All Purpose Building Permit Application - AMENDMENT

February 12, 2002

Re: Waiver Request/ 95 Chadwick St. BP#020079/063 F005

This office has received waiver requests for two code items at the above location:

Sleeping porch
window - Sec. 1010.4

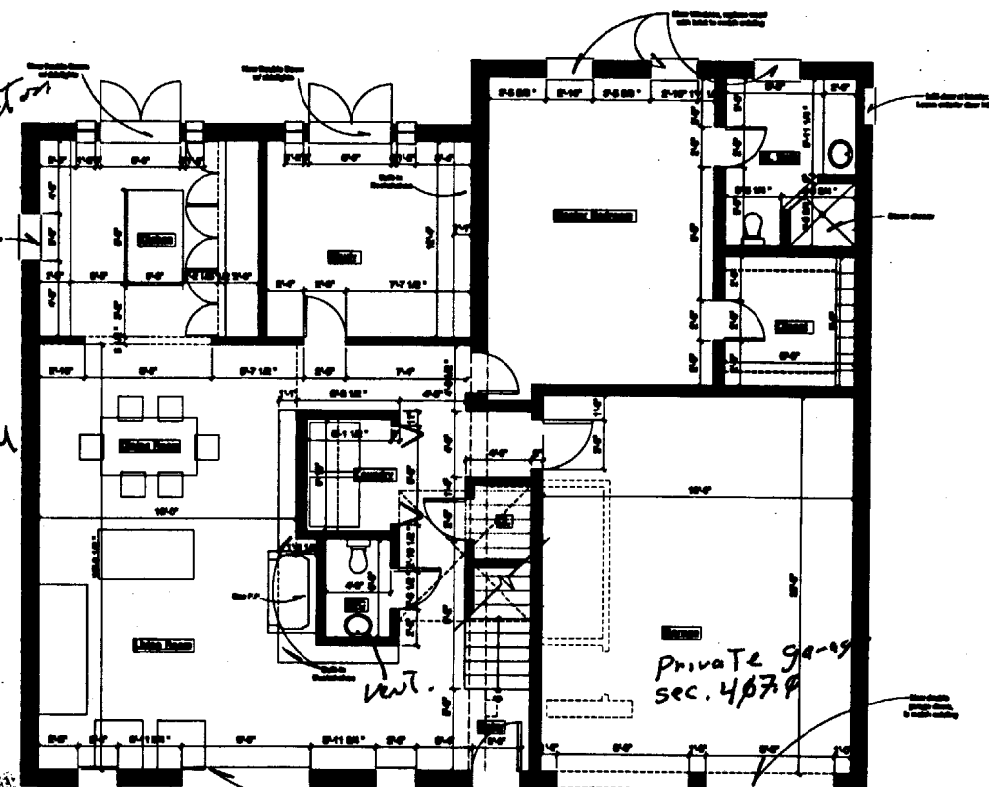
- 1) 5.0 Sq.ft. egress windows in the first floor sleeping room;
- 2) 8.75 net treads on the cellar stairs.

Item one is hereby approved as it complies with Section 1010.4 exception 1, and the Fire Dept. does not exercise NFPA jurisdiction in Single Family Dwellings.
